A Proposed Shed on land opposite The Granary, Wepham, Arundel, BN18 9RA

Our Ref: **B/17/11/**

Proposed shed on horticultural land
Land opposite Wepham Farm Barn Wepham The Street

PROPOSED
PLAN & ELEVATIONS
DWG 01/P03-

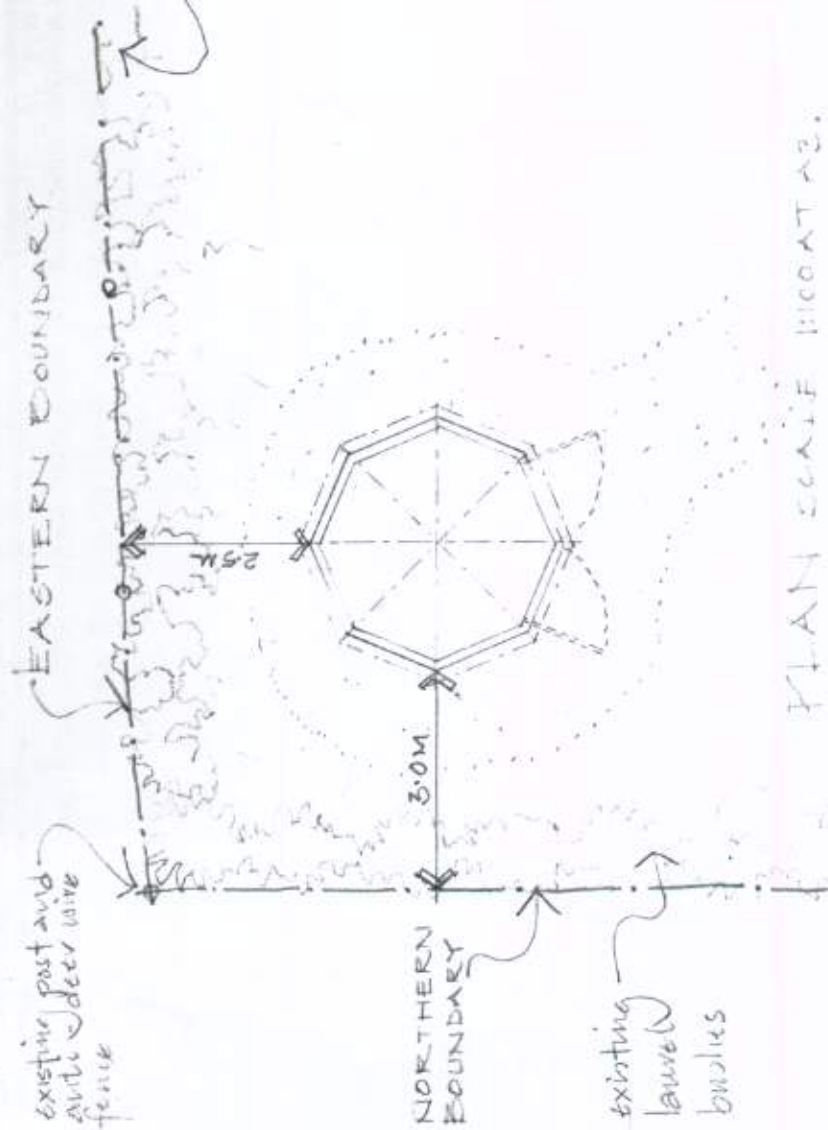
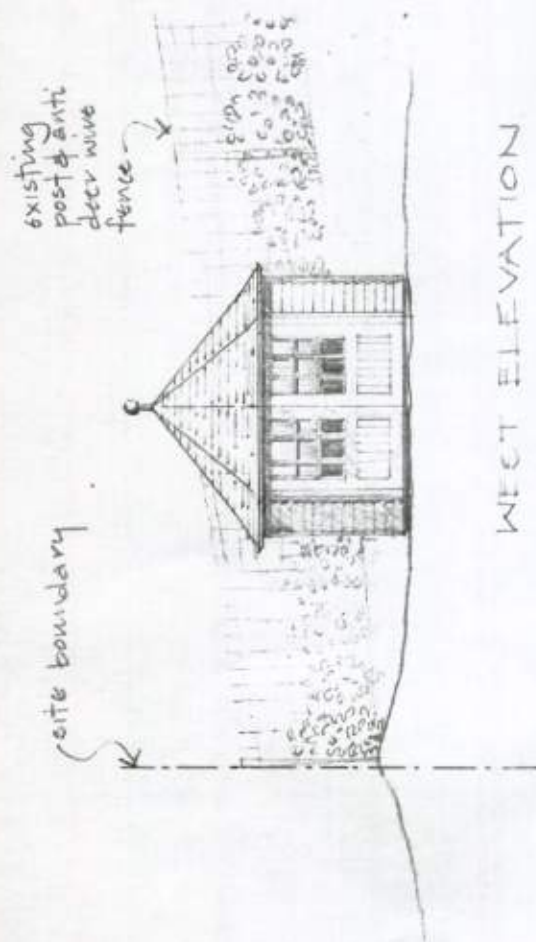
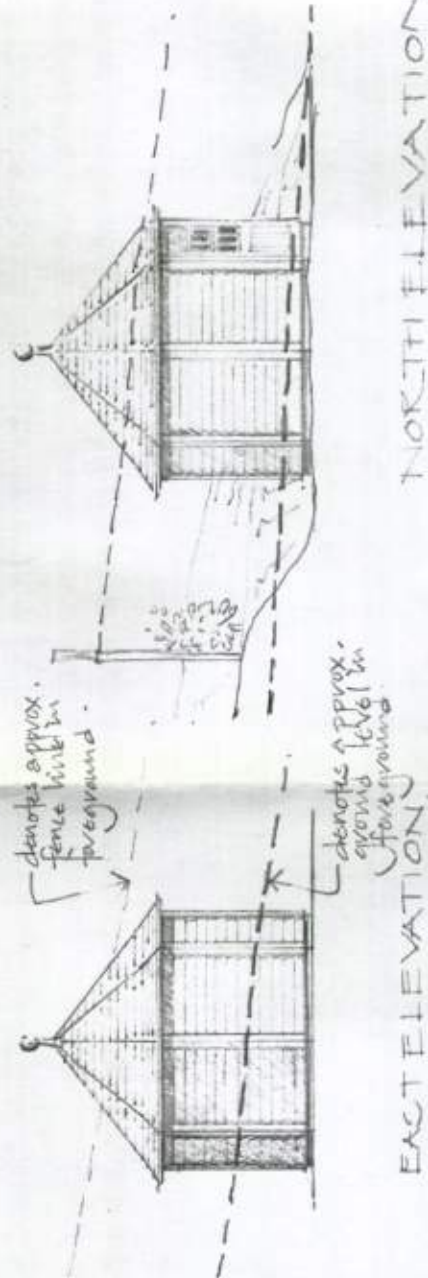
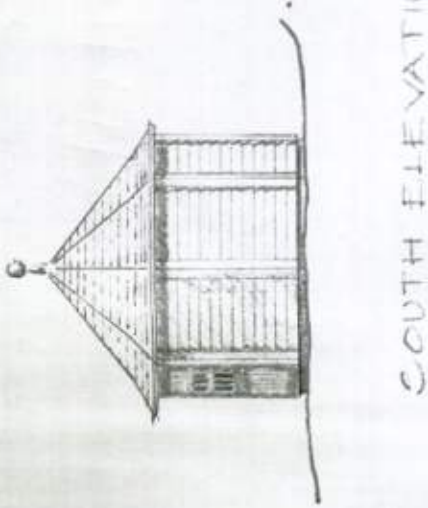
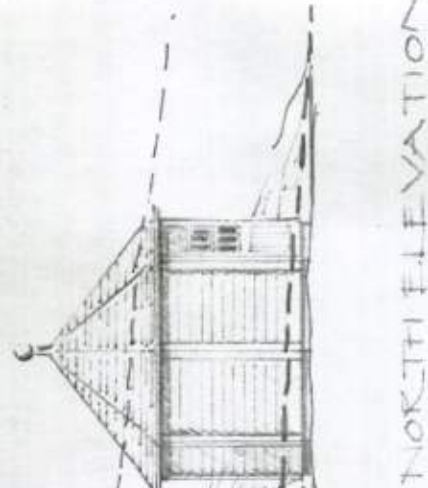
Please provide 1 electronic or 3 paper copies of a revised floor plan and elevations at a scale of 1:100. The plans provided are not to scale. ✓

- 3No. copies of Site/Block Plan drawing HBPE 28.02A with proposed shed position clarified.
- 3No. copies of proposed plans and elevations drawing HB51/P03- of the shed at scale 1:100 as
